REQUEST

Current Zoning: R-17MF (multi-family residential)
Proposed Zoning: UR-2(CD) (urban residential, conditional)

Approximately 1.53 acres located on the south side of Lynnwood Drive, west of Sterling Road, and north of Ridgewood Avenue.

The petition proposes to redevelop a site with 18 existing multi-family units to allow for the development of 21 new townhomes.

RZ-1.0

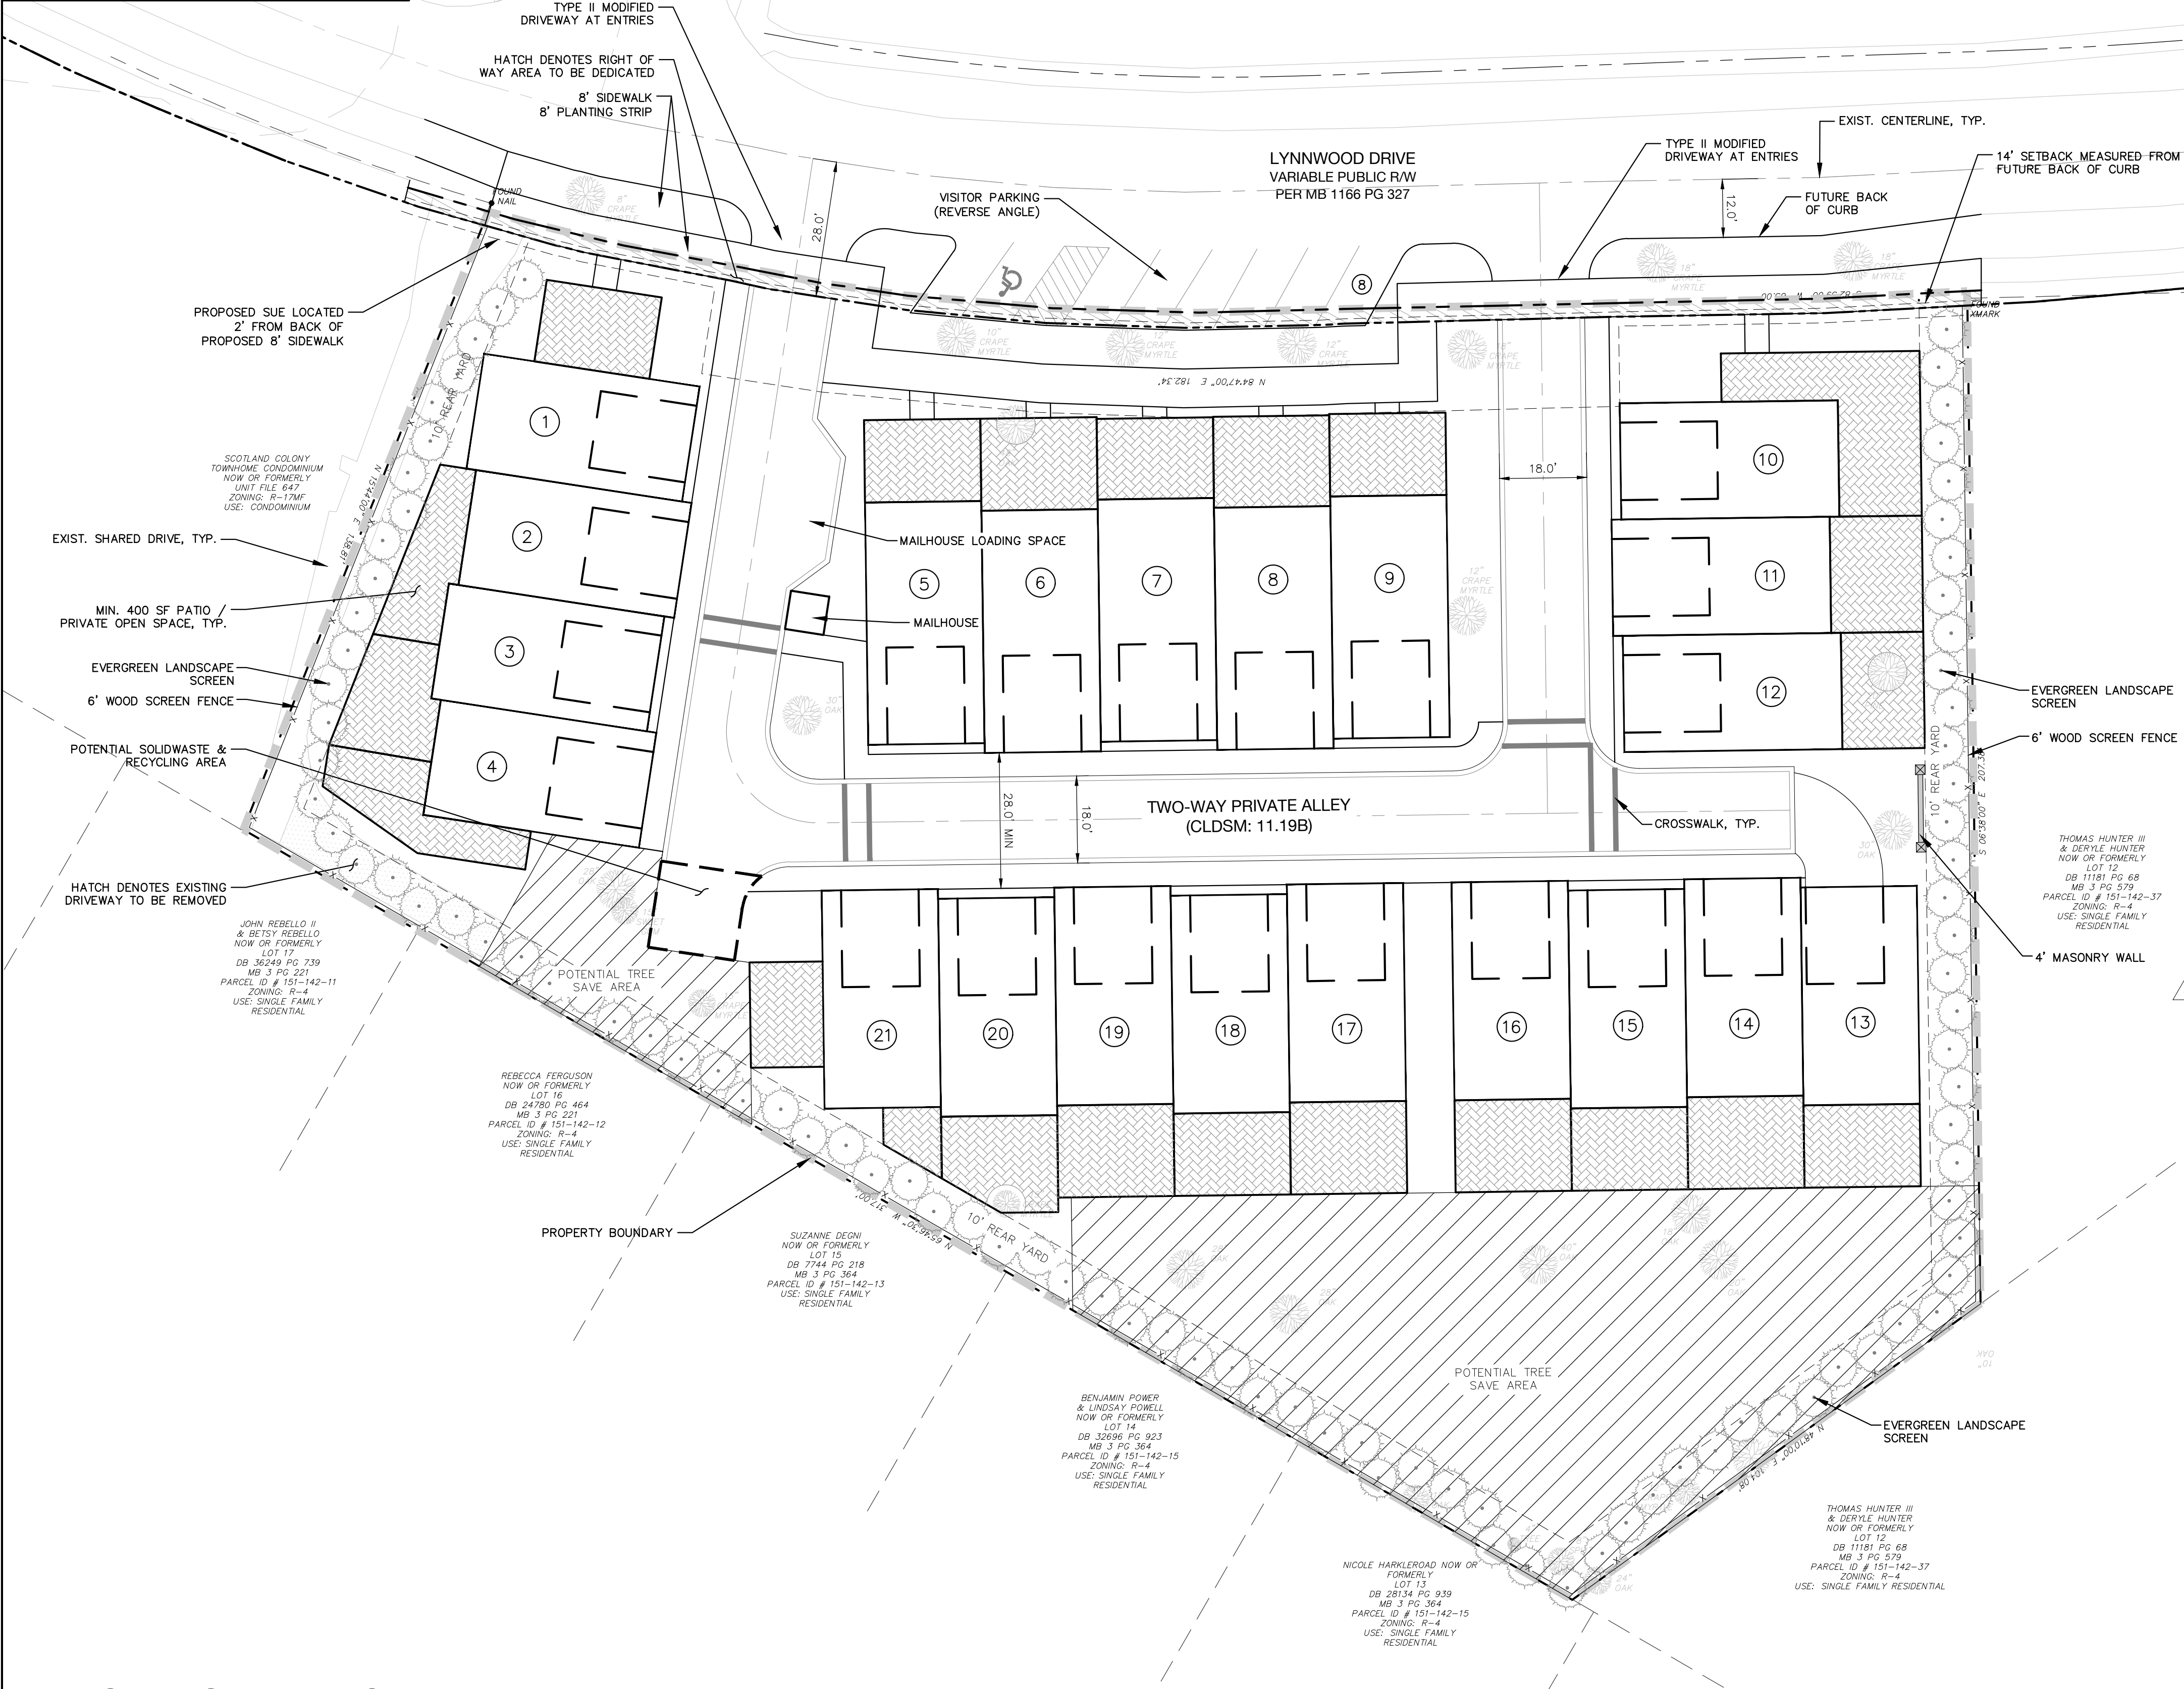
1. ~~Label and dimension the curb and gutter from the centerline for each road on the site plan. The site plan should show dimensions as measured from the centerline to the back of curb.~~ **Addressed**

2. ~~Remove language allowing additional height beyond 40' in note g. under Architecture and Design Standards.~~ **Comment Rescinded**

3. ~~Clarify in the conditional notes that the arborist plan will be done prior to development plan submittal and clearly identify which trees outside of the tree save area are to remain.~~ **Addressed**

4. ~~Add note that patios shall be at-grade and covered.~~ **Addressed**
5. ~~Add language in the conditional notes specifying that the open space requirement is being met with private open space, as shown on the site plan.~~ **Addressed**

6. ~~Revise the language in note 6 of Environmental Features to clarify the rate of new plantings to existing trees.~~ **Addressed**
